Date: 25th June 2019
Your Ref: LU/164/19/PL
Our Ref: 13538

APPLICATION FOR FULL PLANNING PERMISSION AT 5 ARUNDEL ROAD, LITTLEHAMPTON BN17 7BY

Reference	Plan Title
1915-06 Rev C	Proposed Floor Plan
1915-07 Rev C	Proposed Elevations
1915-08 Rev C	Change of Use Floor Plans

Studio Lack Architecture Studio Lack Ltd : 17 Beech Avenue : Chichester 01243 782 686 : nicholas.lack@live.com : PO19 3DR	5 Arundel Road, Littlehampton	Plans for 'Change of Use' 30/03/19 1/100 @ A3	Dwg 1915-08B
--	--	---	---------------------

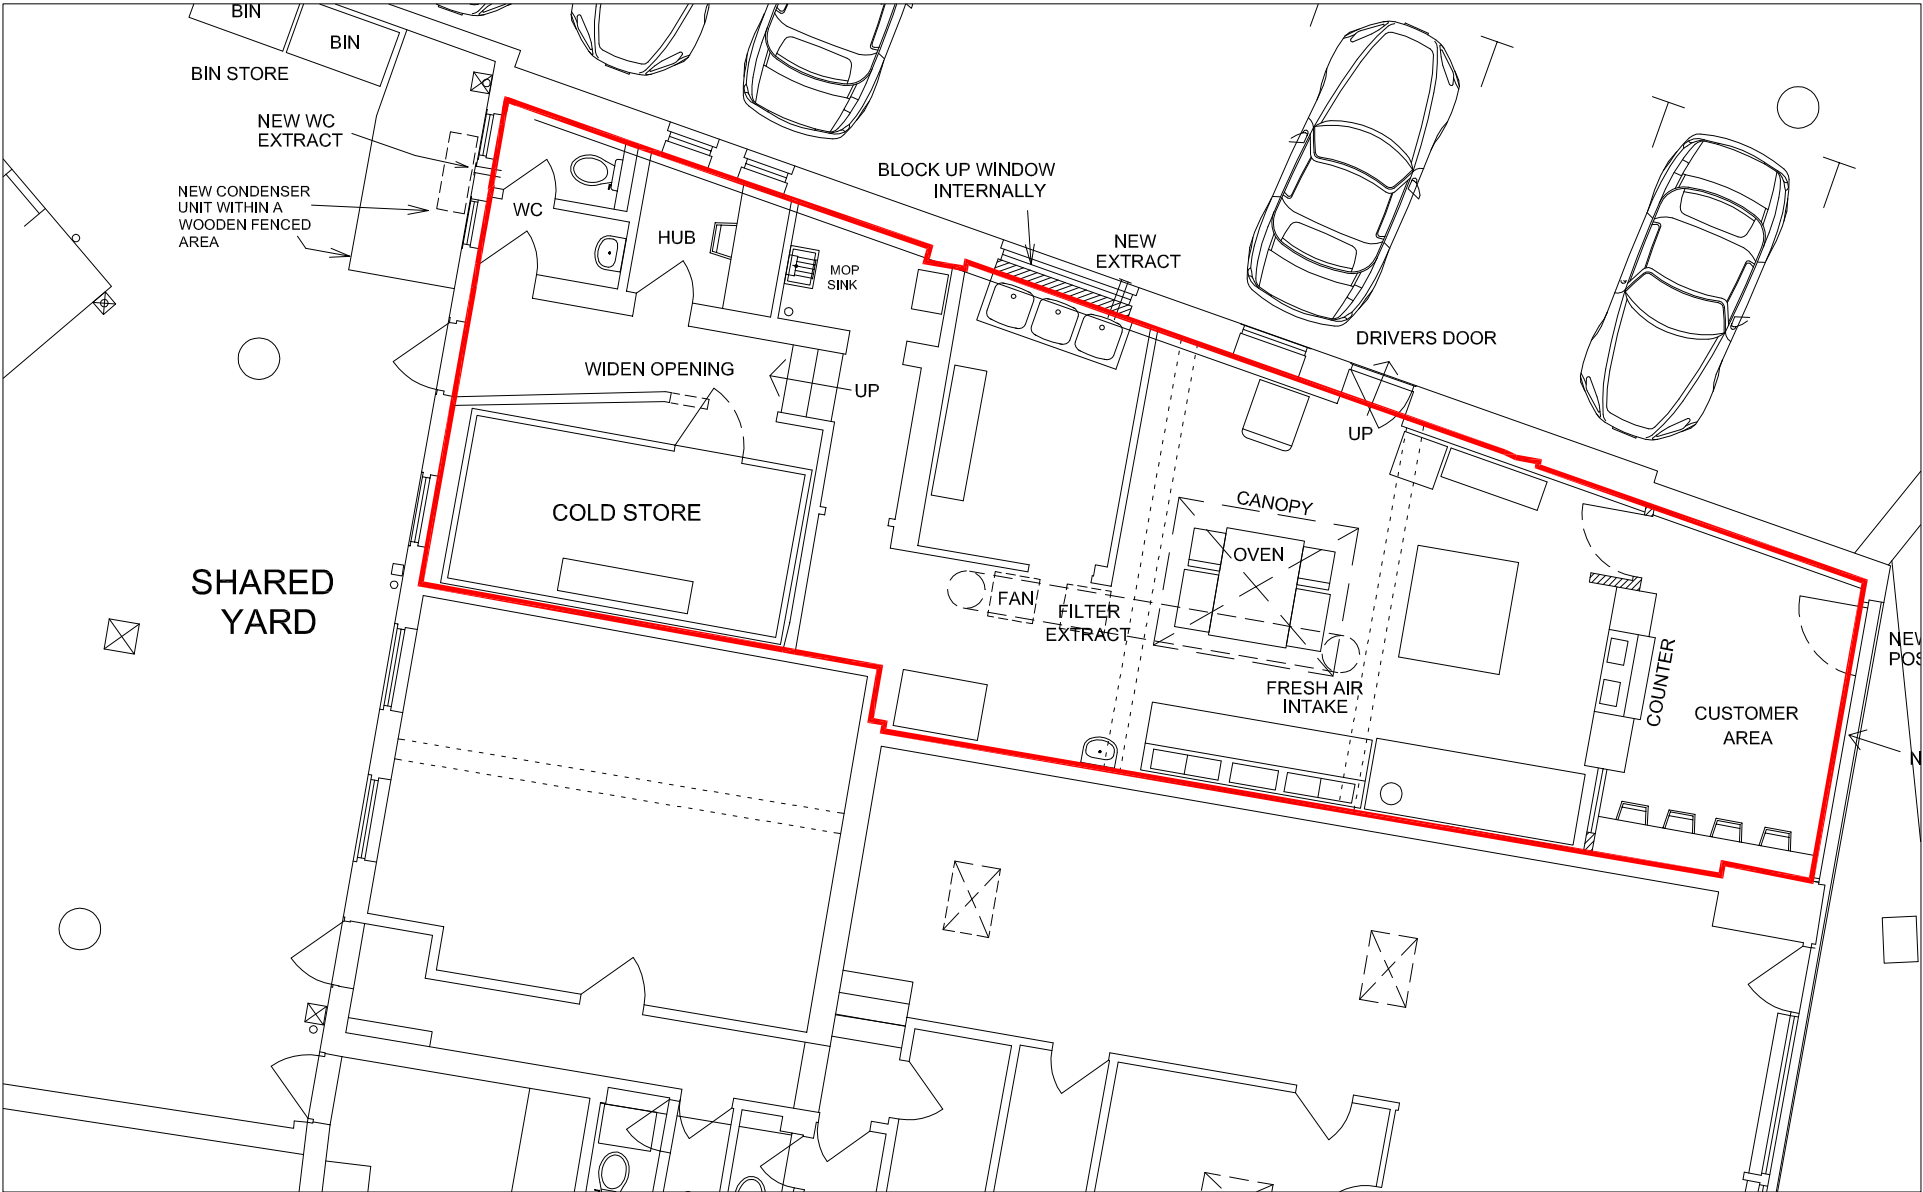
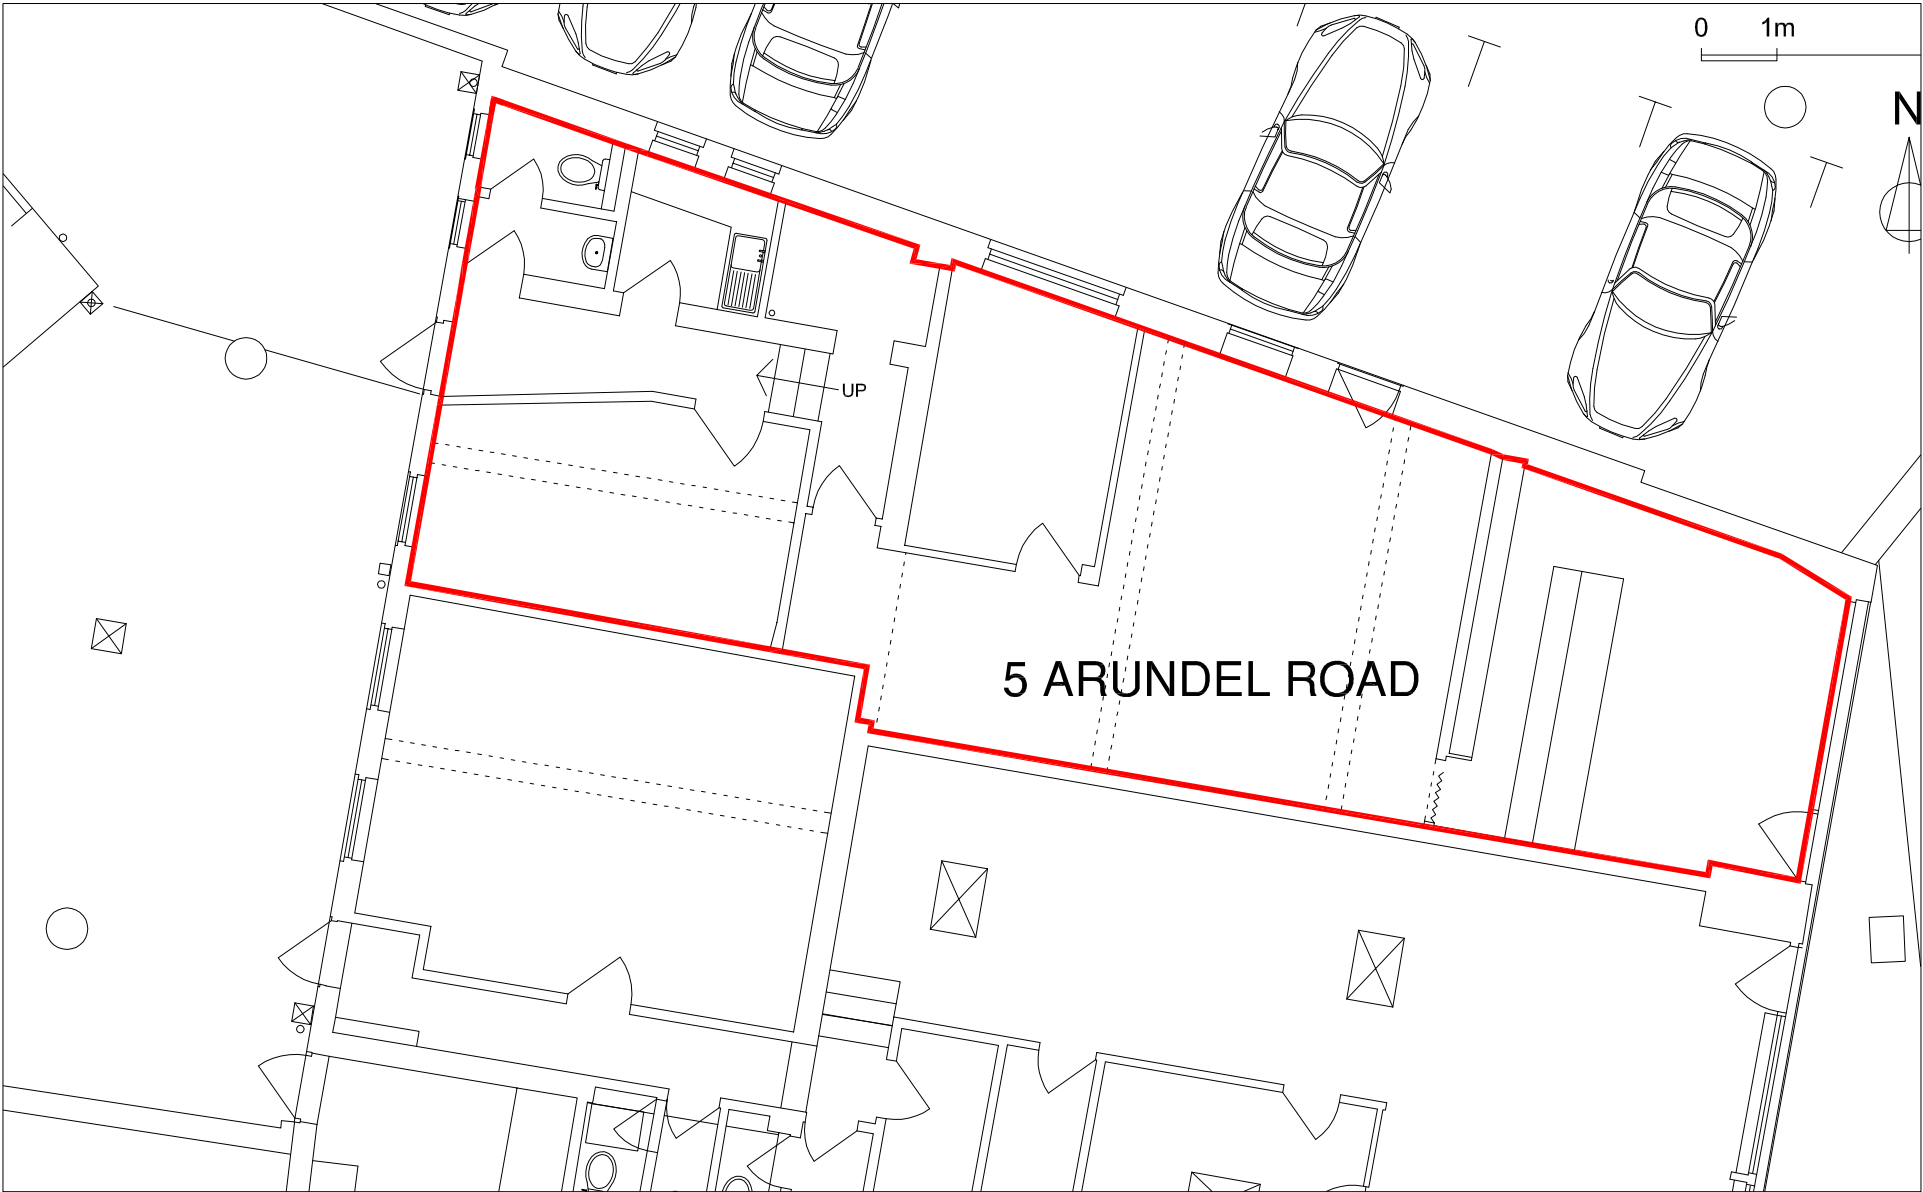
In addition, we submit updated versions of the following plans, which show an amended location of the condenser unit to be installed on the north elevation of the property. Specifically, the condenser unit has been relocated from the south of the rear door to the north of the door. The submitted reports are based on this revised location.
